Application No: R/215/25/HH  
Site Address: 21 Sutton Avenue Rustington BN16 2ES  
Description of works: Single storey rear extension.

Thank you for your internet representation made on 13th December 2025 which has been recorded as an objection with the comments as follows:

Drawing:  
**Plans and elevations as proposed**

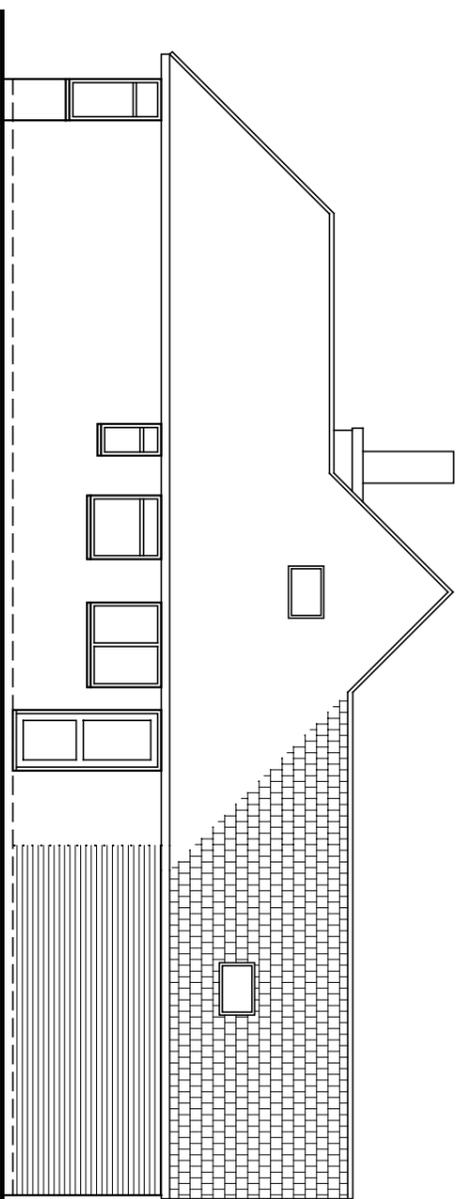
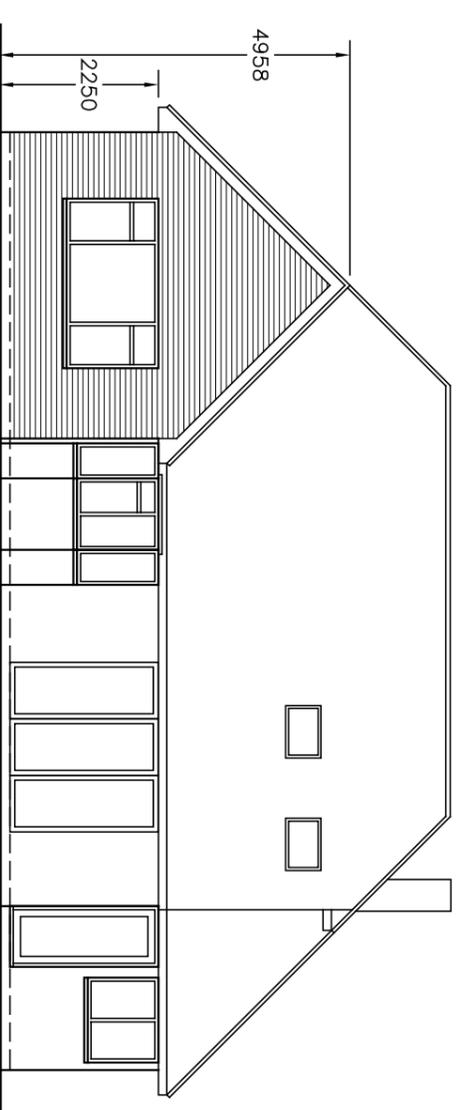
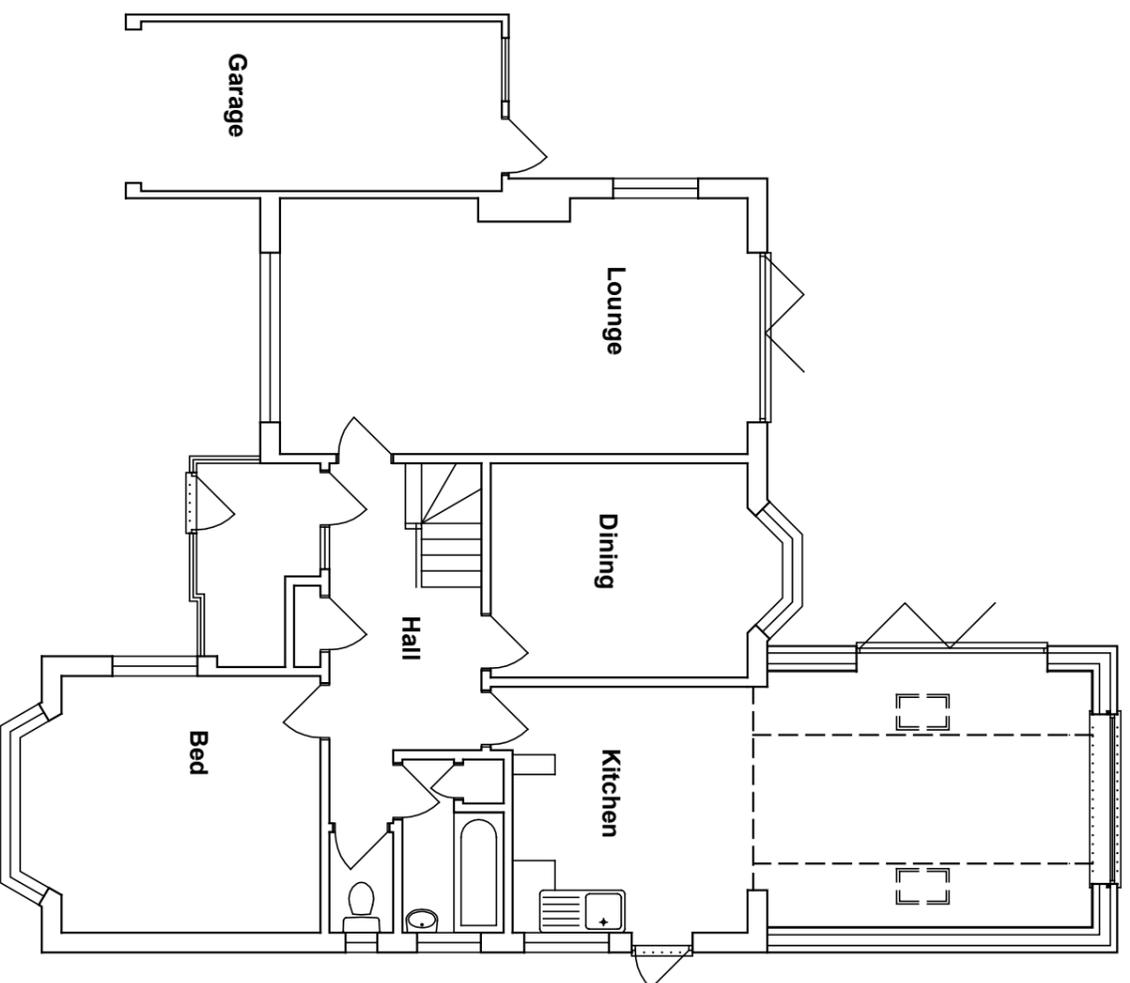
Visual amenity and overbearing impact: The "unsightly wall and gutter outlook" relates to visual intrusion, which is a valid planning consideration. You can argue the extension creates an oppressive or "claustrophobic effect".

includes blocking light to main living area /conservatory,  
no block plan seen on this also,

I object to looking towards my south border ,will see reduce light and 21ft of  
wall and gutter if plans give go ahead,  
cause overbearing overshadowing,  
loss reduction of light
